From: Zac Denton
Sent: 12 April 2018 14:45
To: Karen Parsons
Subject: FW: AW/44/18/HH

I have been looking over your current application that you have with Arun District Council at Lawnswood, Dark Lane, Aldwick.

Project/Address	Side Extension & reconfiguration Lawnswood, Dark Lane Aldwick West Sussex, PO21 4AJ	DRAWING	Proposed Plan
		Drawing No/rev	C9/0126/05
		Scale	1:100 @ A3
		Date	January 2018

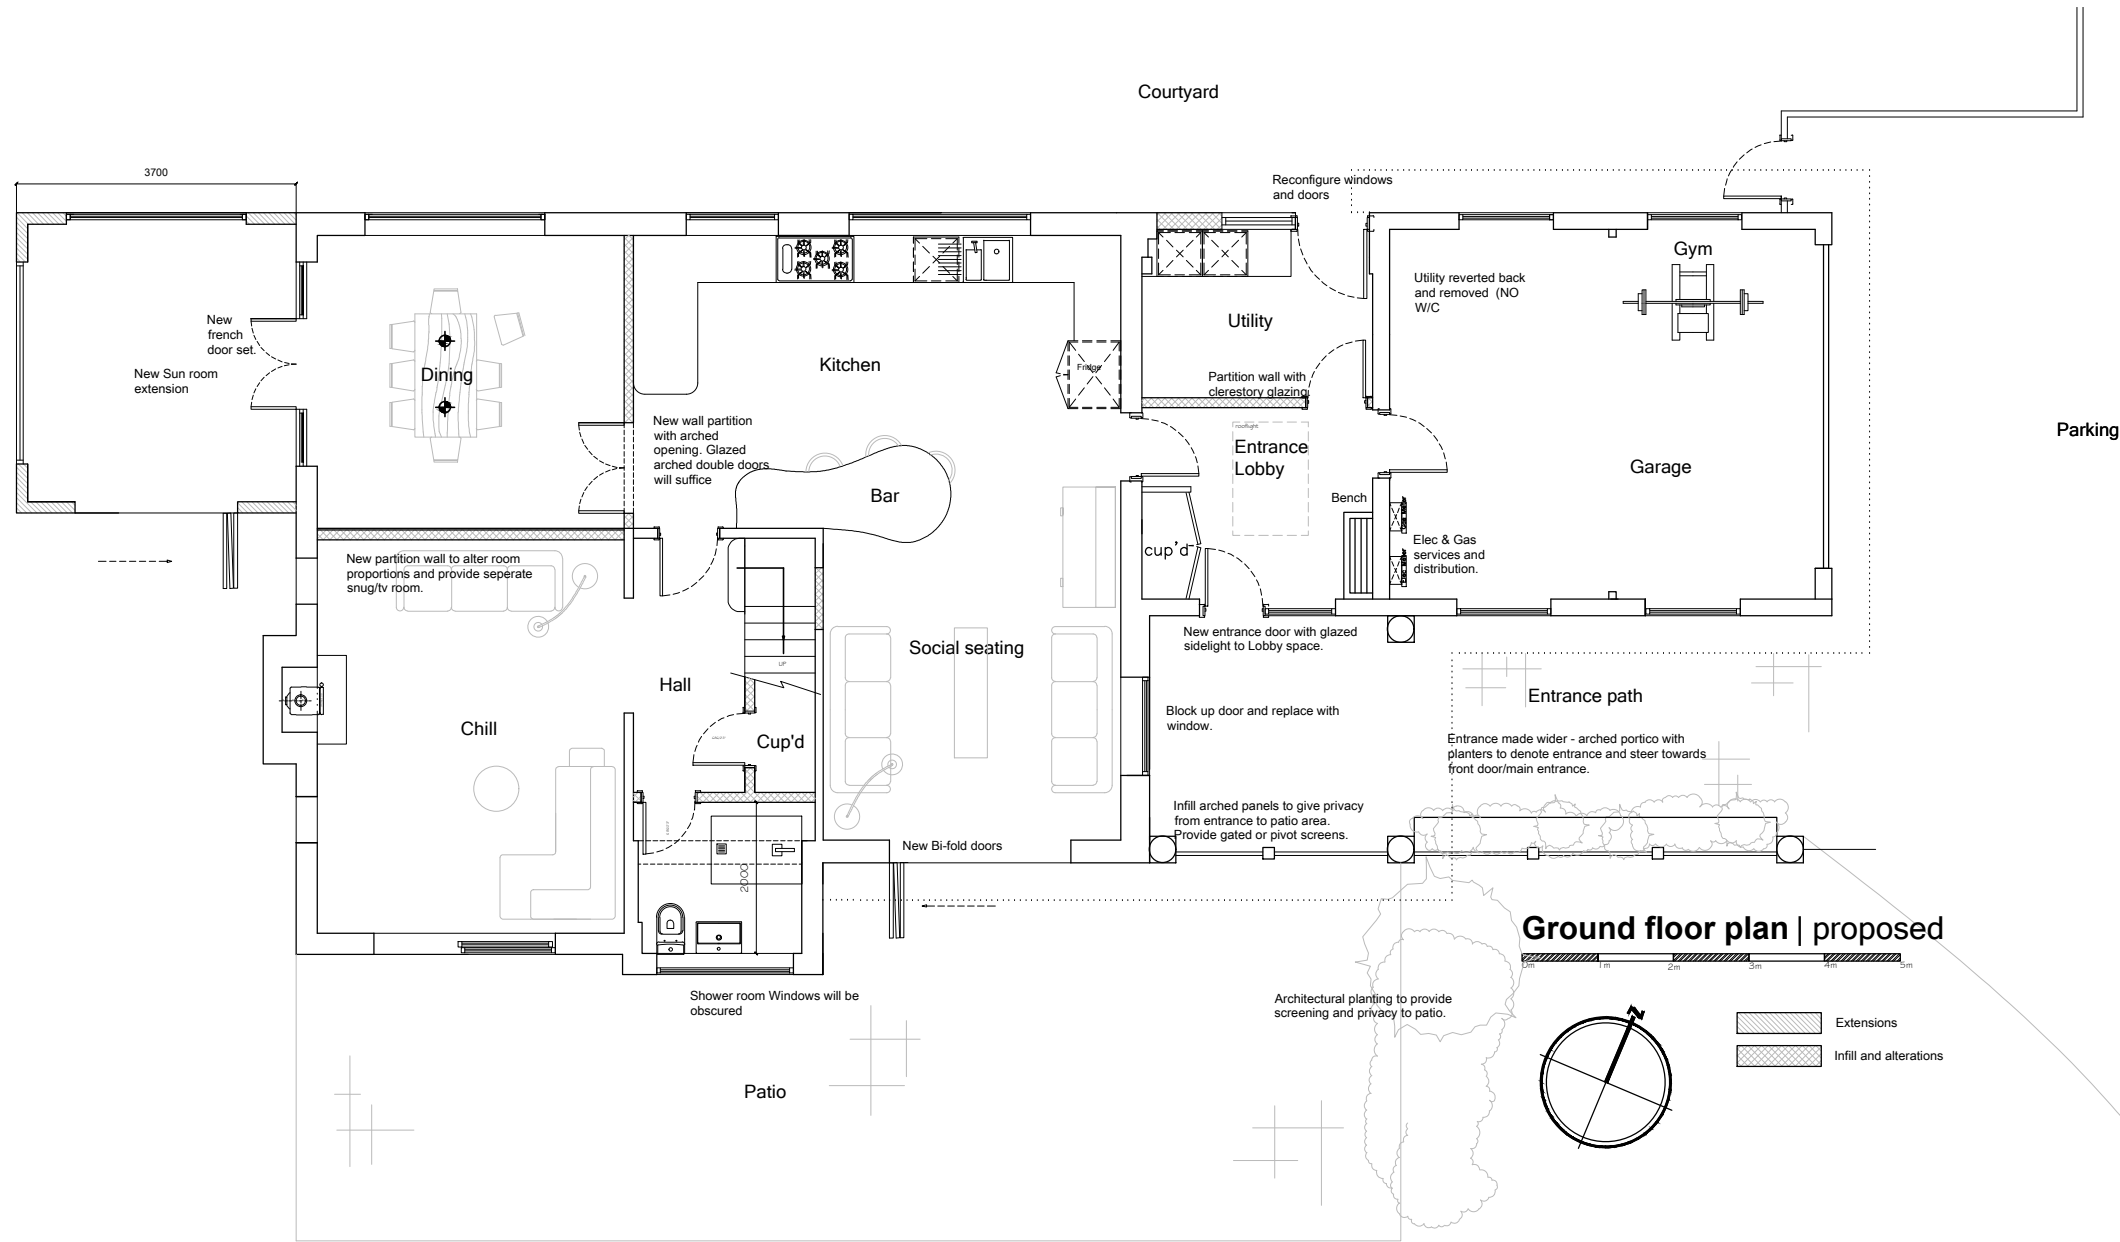
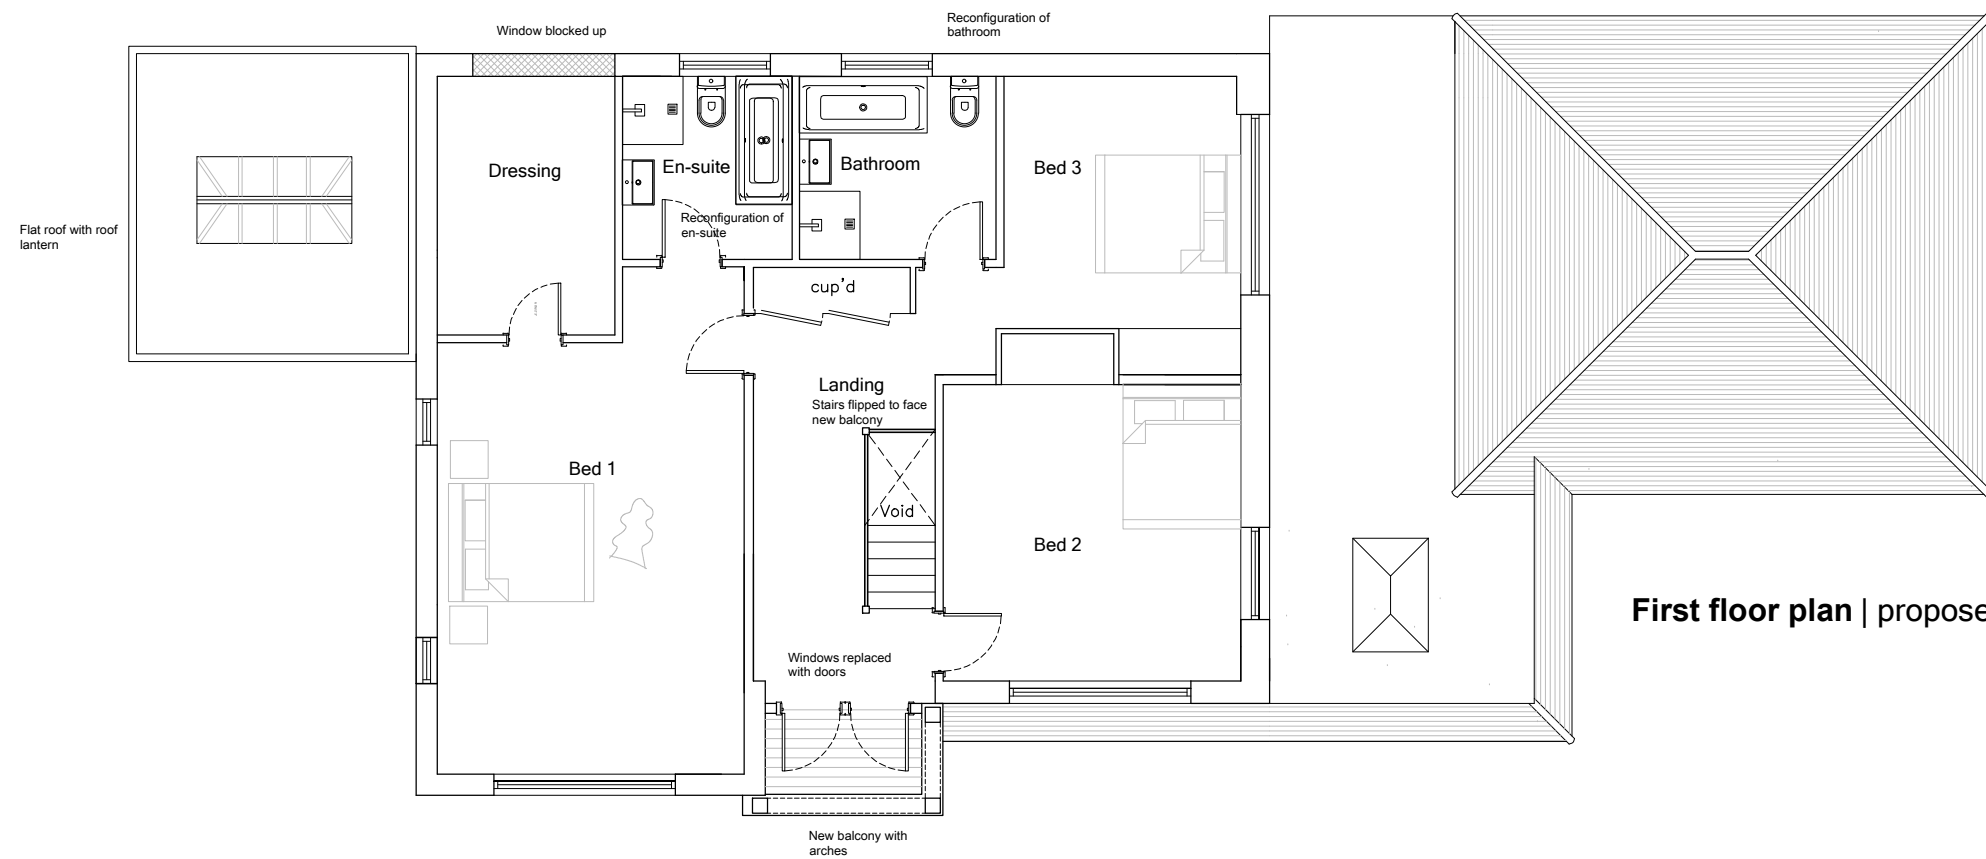
I have found that the majority of the proposal is acceptable, however, I am having some issues with the proposed carport. It is currently 4m high, with a pitch roof, would you be open to a proposal to potentially lower the height of the roof? What about if the roof were to be made a single pitch/cat slide roof?

I have spoken with my Team Leader and he agrees with me that the proposed carport shown in the drawings is deemed to fix the issues we were having with the original scheme.

I have attached for your comments a quick sketch of the side elevations of the catslide version that we discussed, if we move this a further 250mm off the boundary and make the proposed roof changes the impact is reduced significantly.

The main roof will still be hipped but with the catslide tapering off the two hips at the rear.
